**Application Reference:** 2025/1025

**Site Address:** 153 Middlecliffe Lane, Little Houghton, Barnsley, S72 0HW

**Introduction:** This application seeks full planning permission for a single storey front extension to a two storey dwelling.

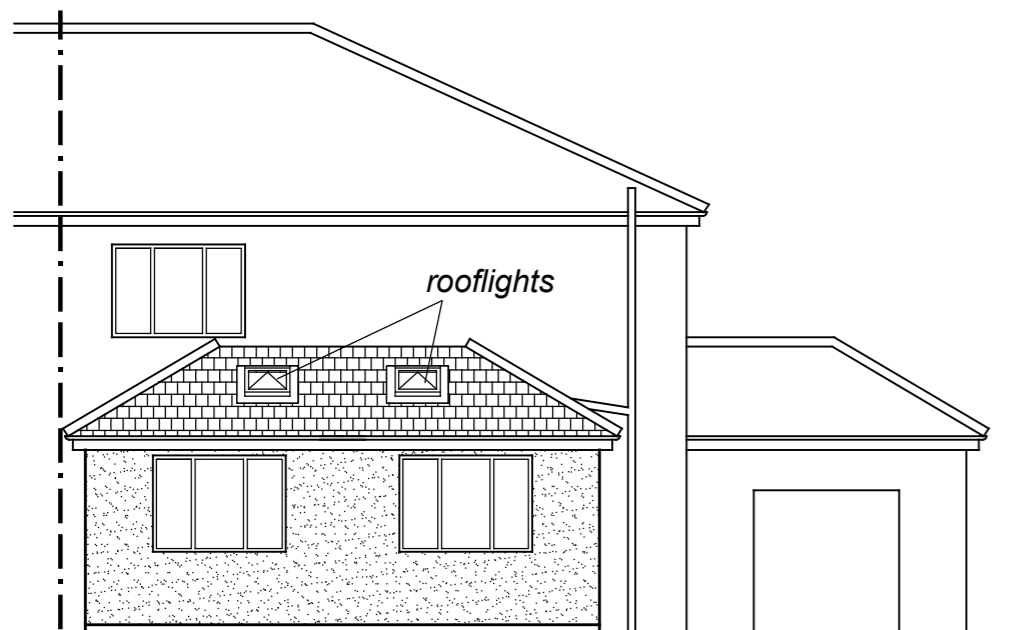
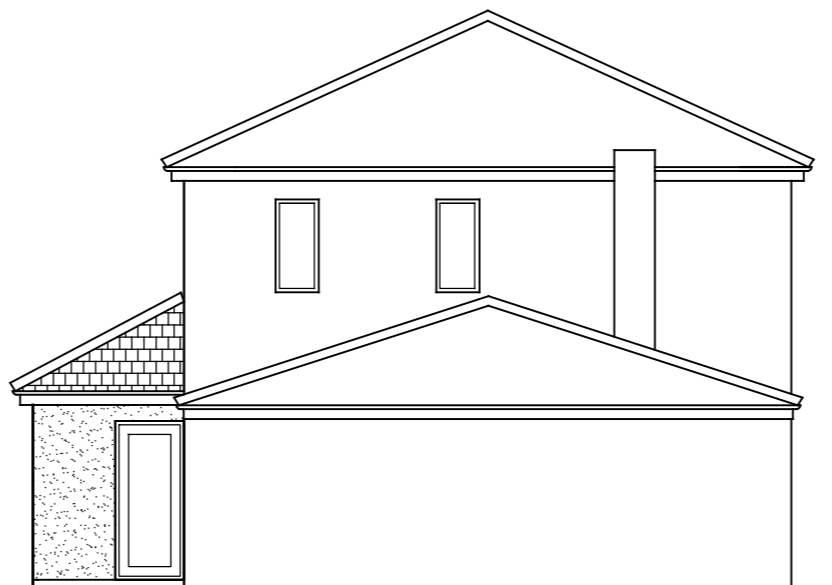
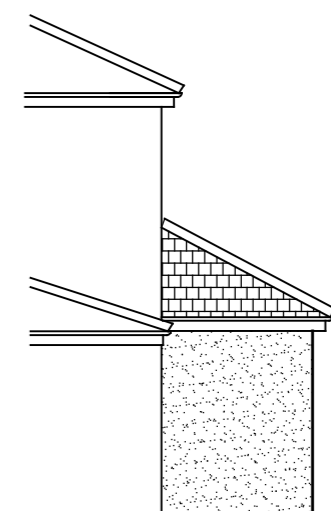
The amended proposal retains its wide width, covering over 80% of the original front elevation, and relocation of the front door to the side elevation of the proposed extension. Both these issues would be considered as not ideal in relation to the scale, design and impact on character. In a more positive note, the projection of the front extension has been reduced to 2m, and provides an overall footprint of just under 14m, an approximate 20% increase to the footprint of the original dwelling.

Whilst the eaves height are a little higher than would be preferred, at 2.6m, the ridge height is 3.9m, the same as the existing garage, but only reaches this height approximately 2m away from

the boundary treatment with No151, again minimising any impact. For the unattached neighbour at No155, given the substantial distance between the extension and their dwelling, there would be no impact of overbearing.

- The original size of the front projection was considered too large and was requested to be reduced.
